CITY OF ALBUQUERQUE

Re: 7411 Hancock
7411 Hancock Ct. NE
30-Day Temporary Certificate of Occupancy
Transportation Development Final Inspection
Engineer's/Architect's Stamp dated 5-28-19 (D17D099)
Certification dated 7-3-19

SITE PLAN

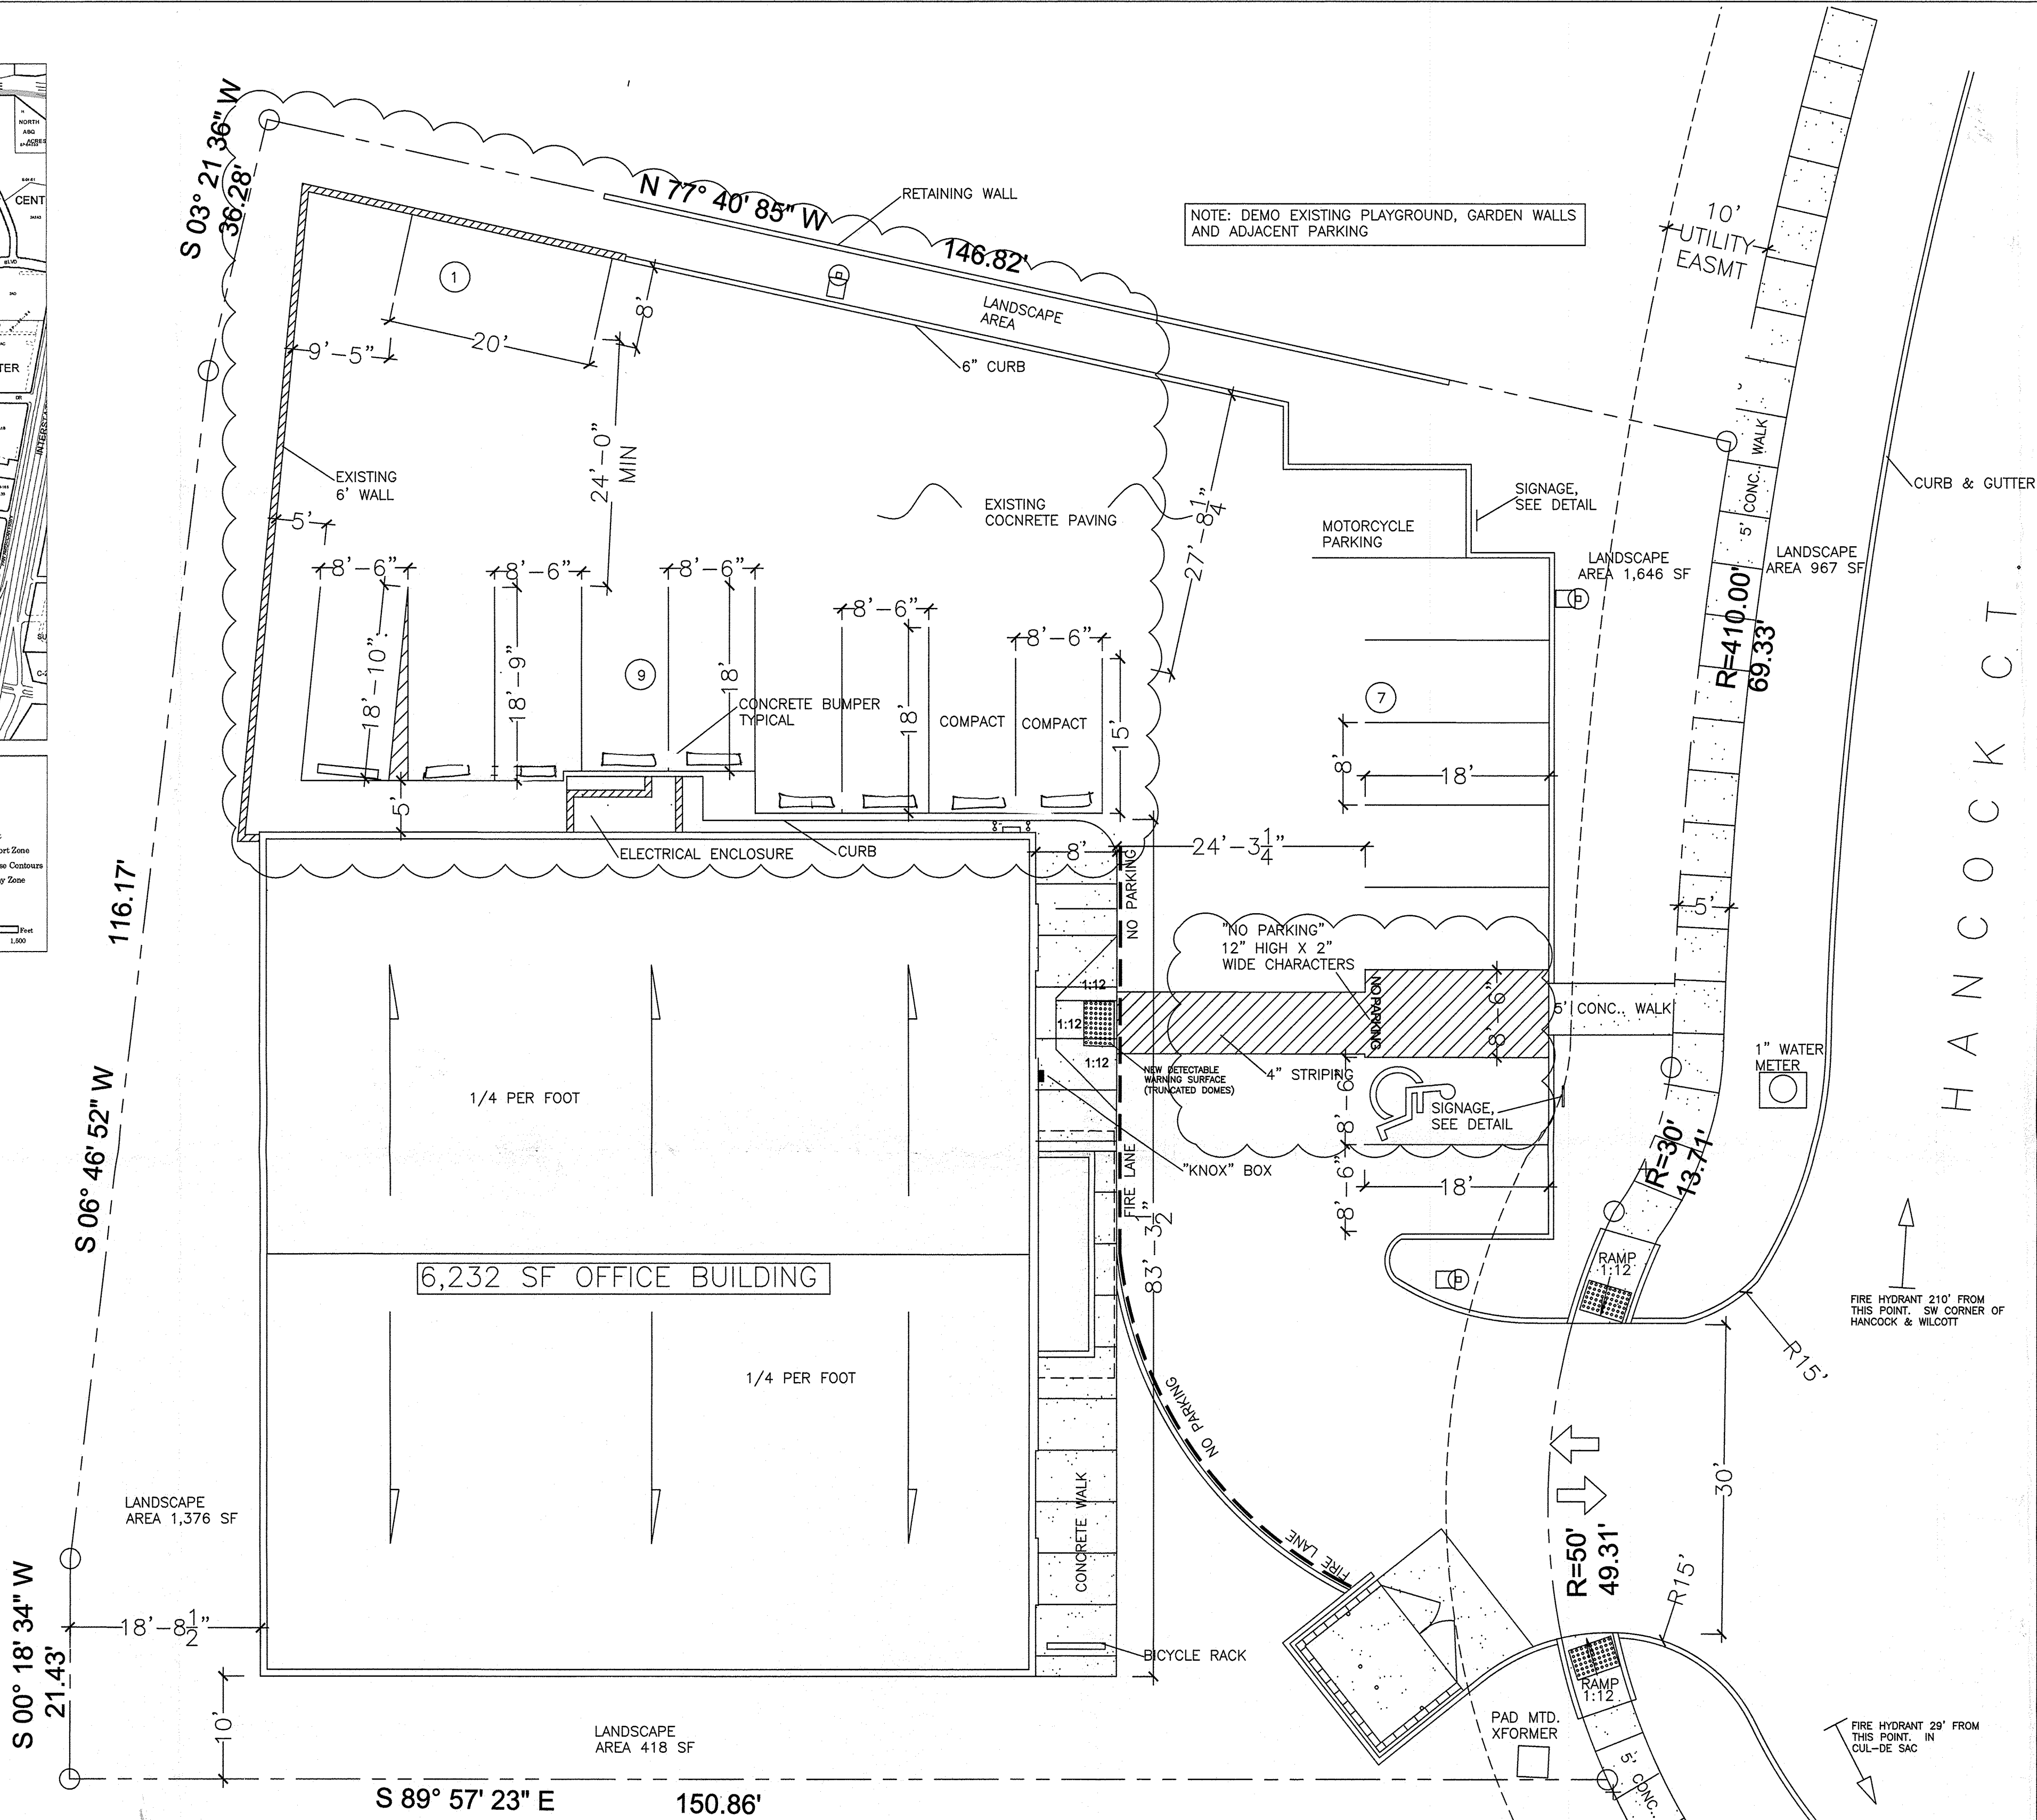
1. Please label Compact stalls. Label the compact parking spaces by placing the words "**COMPACT**" on the pavement of each space.
2. The ADA access aisles shall have the words "**NO PARKING**" in capital letters, each of which shall be at least one foot high and at least two inches wide, placed at the rear of the parking space so as to be close to where an adjacent vehicle's rear tire would be placed. (66-1-4.1.B NMSA 1978)

- 3 Please add wheel stops per the approved TCL Plan
